H22-0382-11
16 MAY 2011

Application for a non-material amendment following a grant of planning permission.

Unit:		House number:	247	House suffix:	
House name:					
Address 1:	BROADGATE				
Address 2:	WESTON HILLS				
Address 3:					
Town:					
County:					
Postcode (optional):	XX				
Description of location or a grid reference. (must be completed if postcode is not known):					
Easting:		Northing:			
Description:

PROPOSED SINGLE STOREY REAR EXTENSION

Drg Size	Drawing Number	Revision:
a1	1964 - 04	C

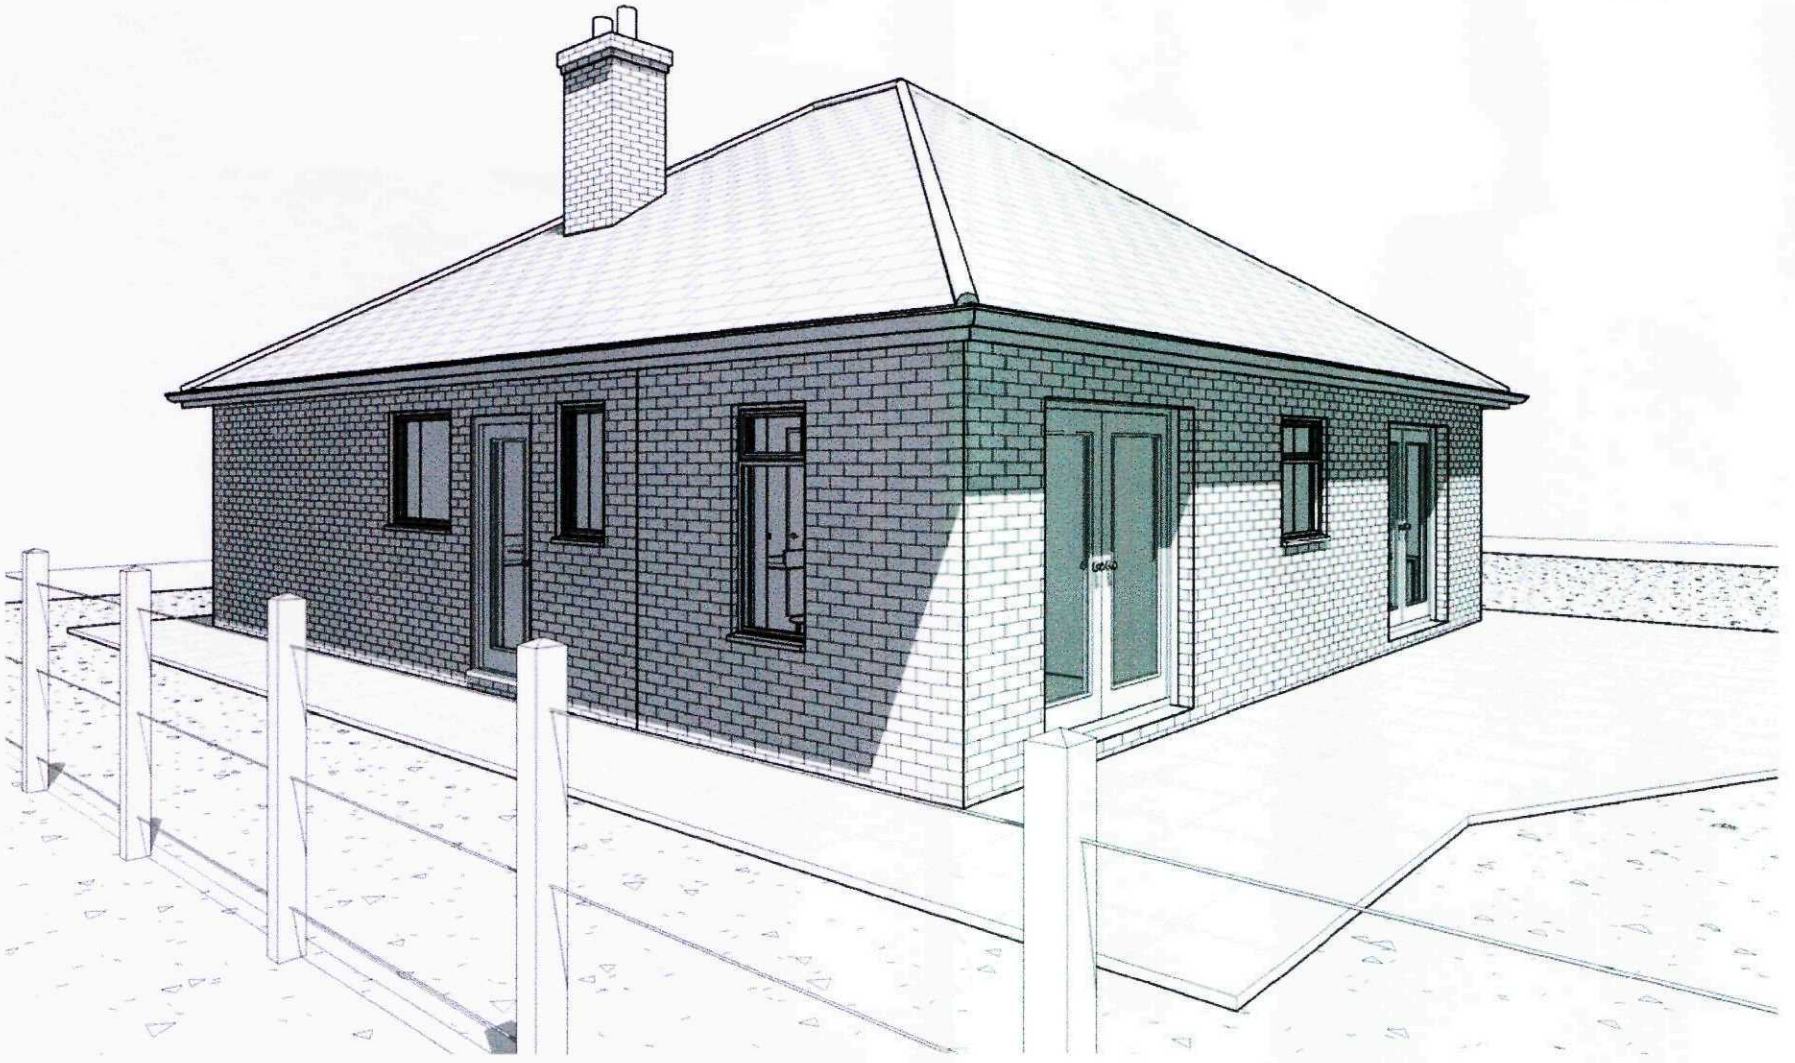
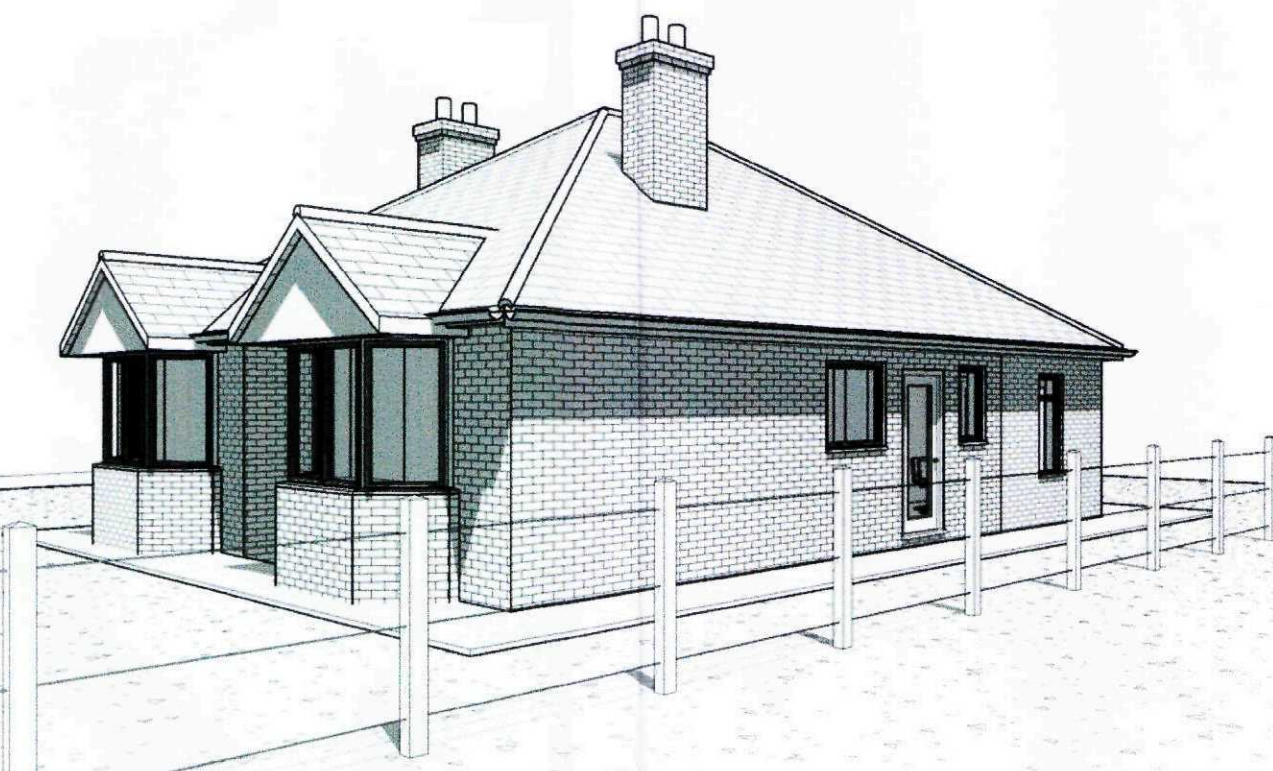
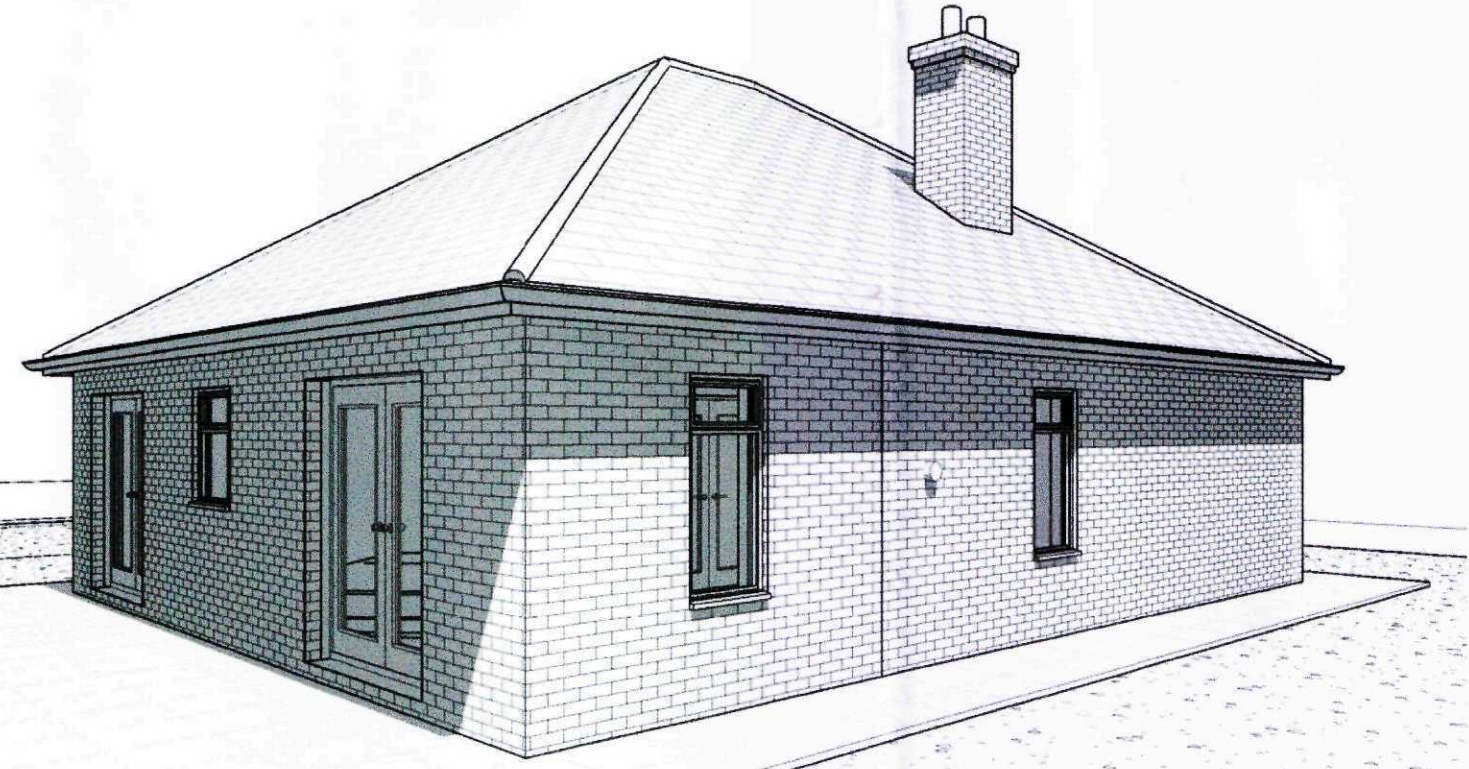
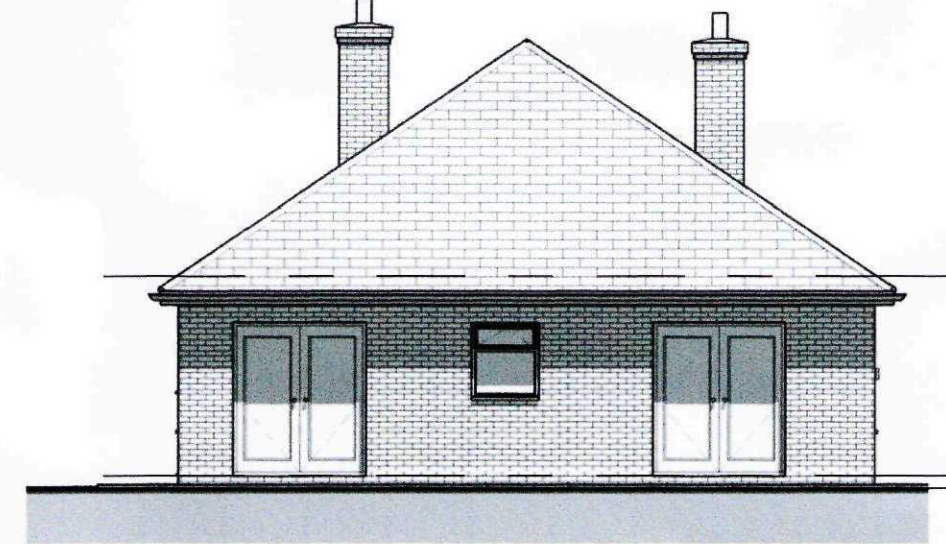
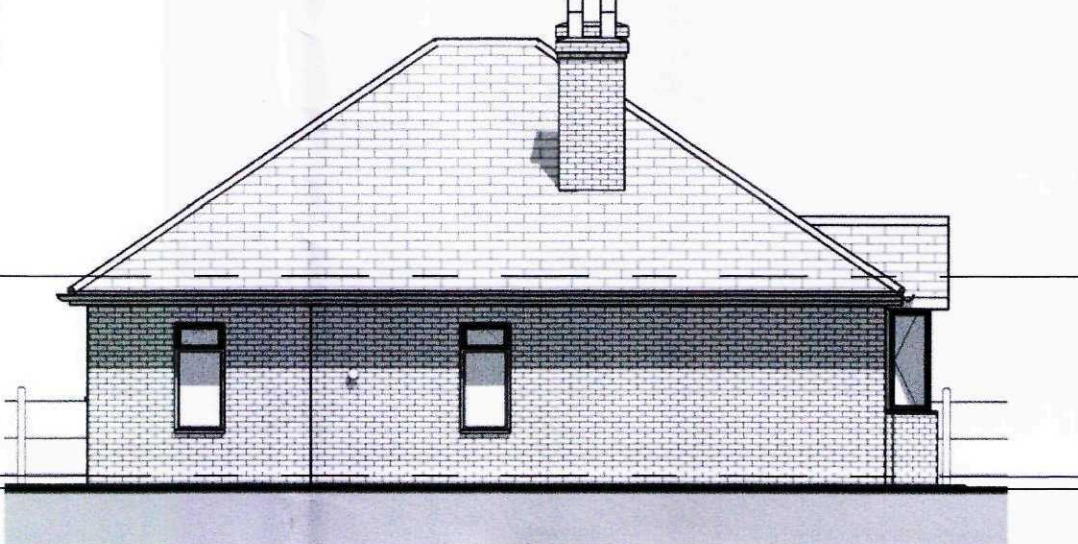
* TIMBER ~~ROOF~~ PITCHED ROOF TO BAY WINDOWS

* RENDER EXISTING BUNGALOW & PAINT CREAM FINISH.

Replace lead flat roof & cover-up poor brickwork.

1964-04 rev C.
